To: Laura Finn Senior Planning Inspector

From: Dr Maeve Flynn, B.Sc. PhD. MCIEEM, Inspectorate Ecologist

Re: The construction of 7 no. wind turbines and associated infrastructure (Carrig Renewables windfarm) in the townland of Faddan Beg, County Tipperary and potential impacts on bird species with regard to possible connections of local populations of waterbirds with Special Protection Areas in the wider landscape. Focus on Whooper Swan.

Date 12/03/2025

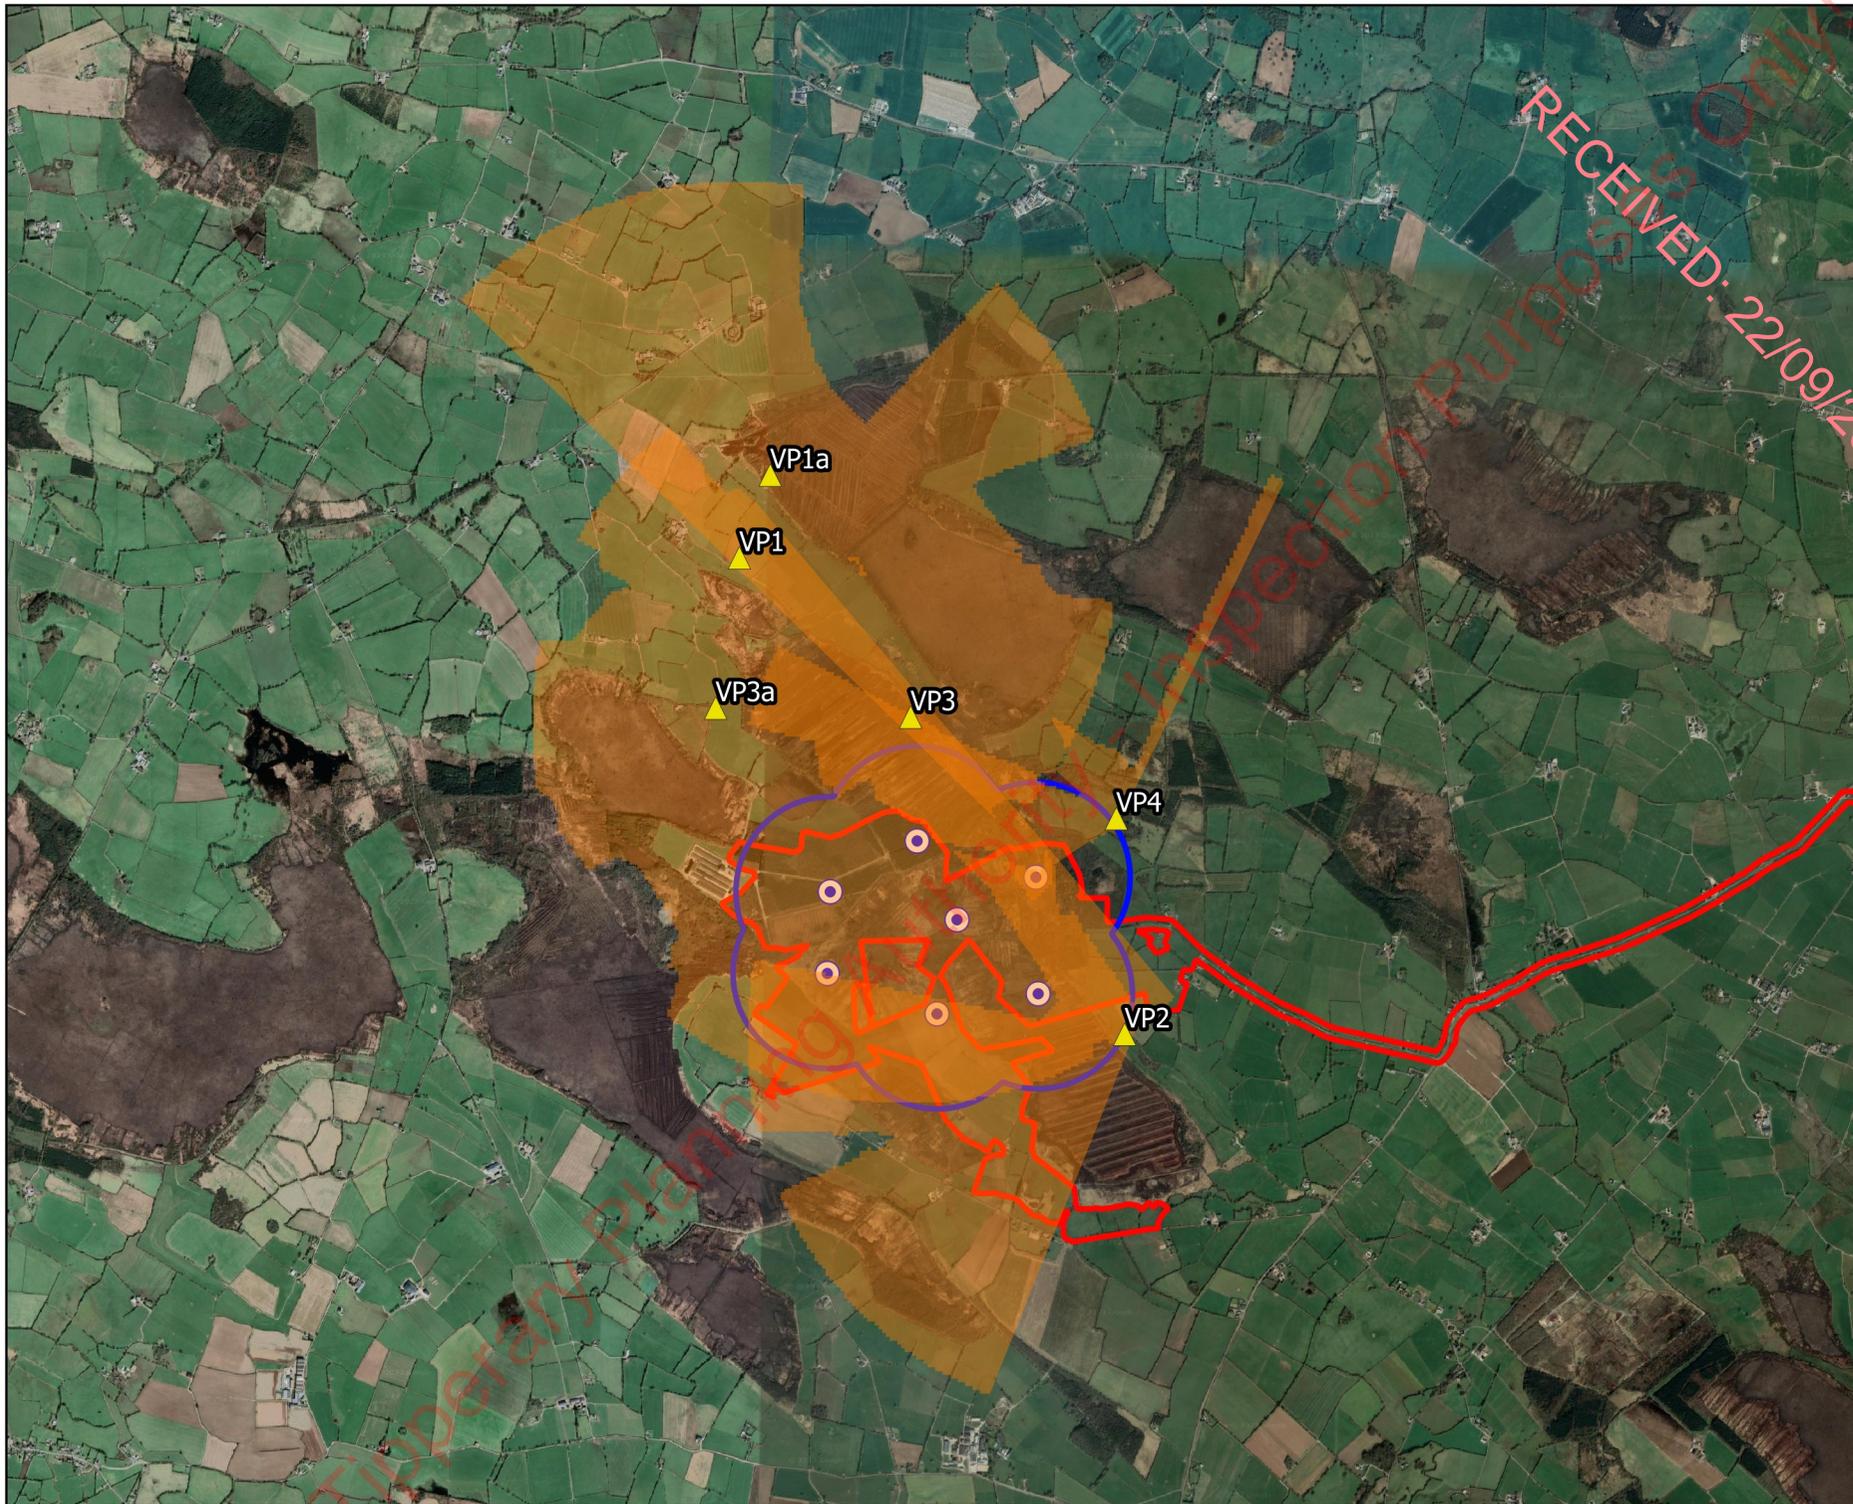
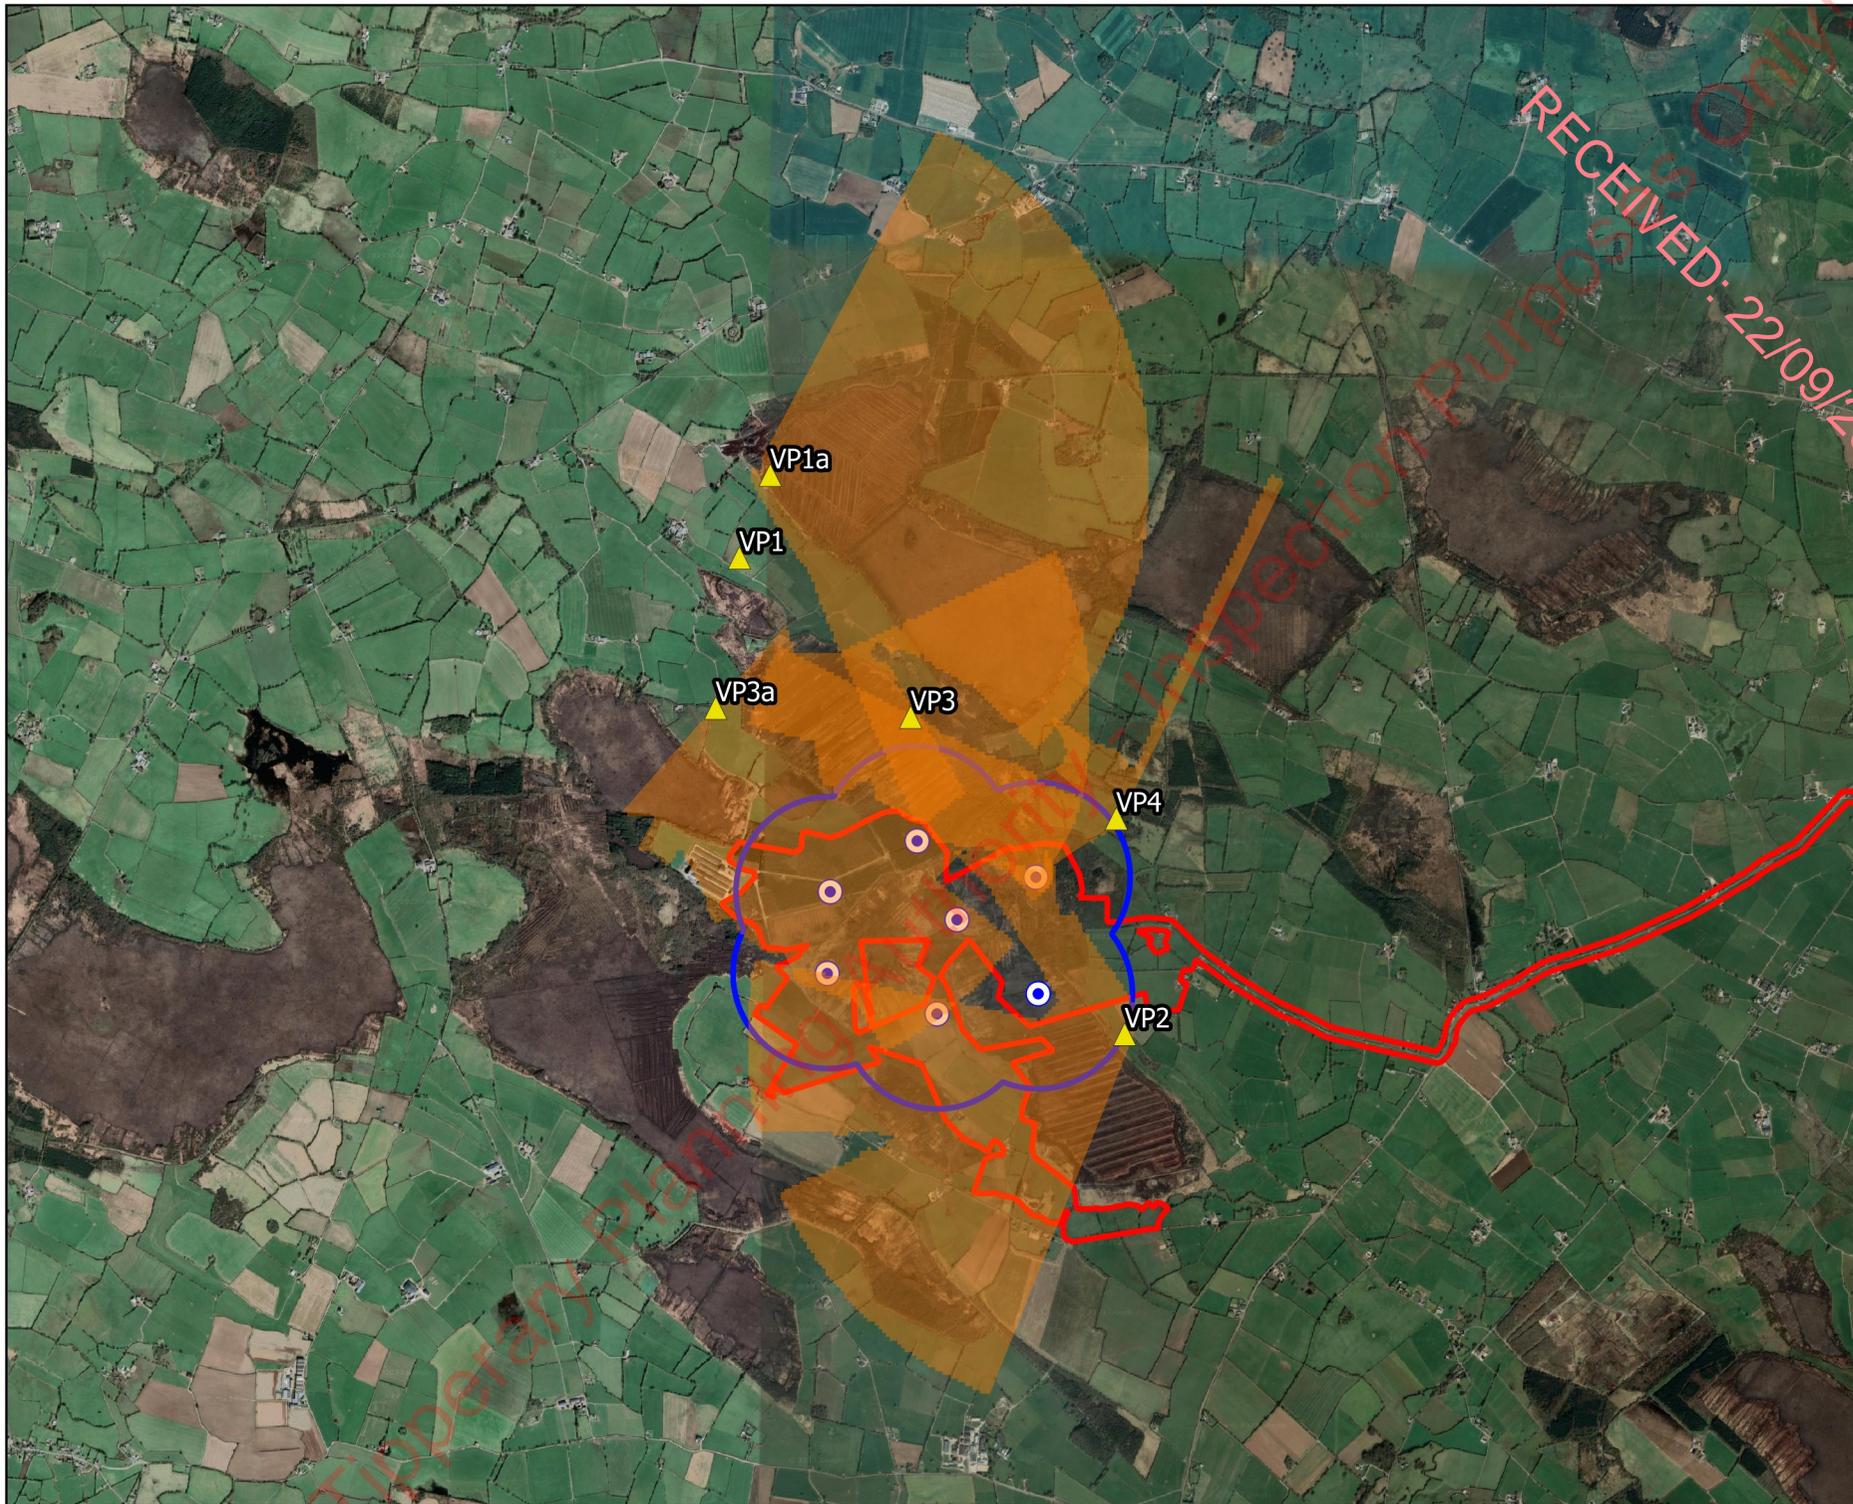
- Vantage point surveys (4 X VPs with 36hrs effort for each survey season- Viewshed presented (Fig 7.2)
- Breeding walkover survey,
